COMMENTS:

WONT BREAK ON 2-8-12 And Tank Uncovered! THE FLAGGED AREA
WAS ONLY 2' FROM TANK- IT HAS TO DISAPPROVE-(5' R/W)

SITE PLAN APPROVAL

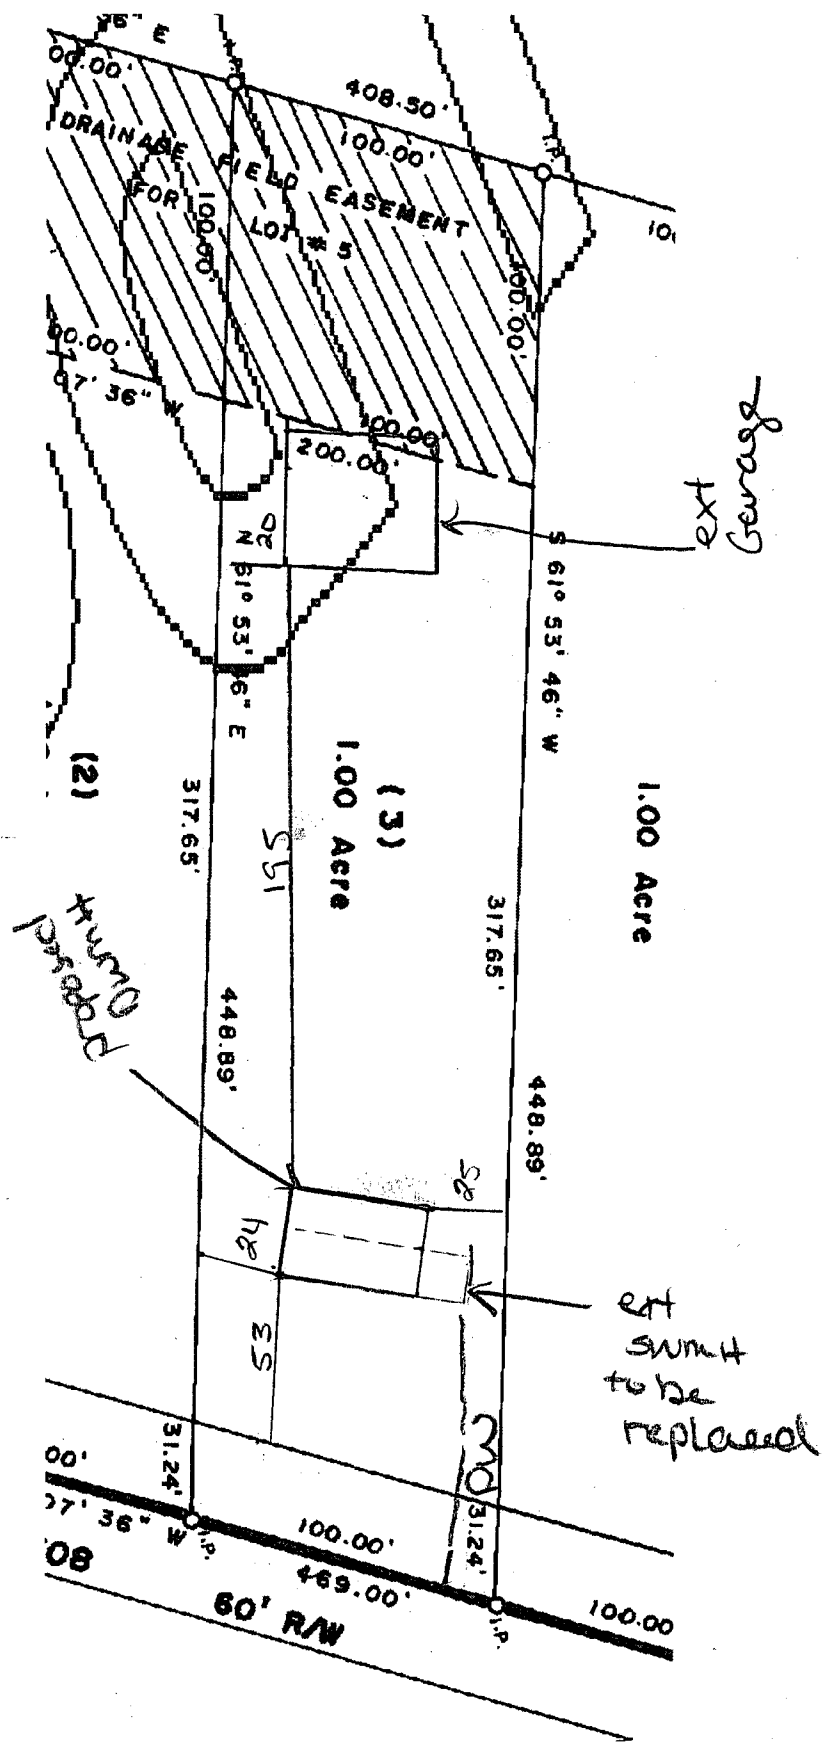
I TRIED TO ADVISE About moving Back of New Downspout to where the back
of Ex SWM was Existing. Mr Montcastle called Back and TOLD
ME NO why he was going to move this that far. He wanted to move
5' only - He said he could add Any back to back of

DIG UP TANK + Lines in Future If he wanted to Add
to ~~the~~ Downspout, I TOLD HIM This would NOT BE ALLOWED
SINCE HE HAD THE OPPORTUNITY TO MOVE NOW AFTER

Being ADVISED of situation it's need to move to back
of Ex SWM to back room for Decks, ADD,

Patios etc.
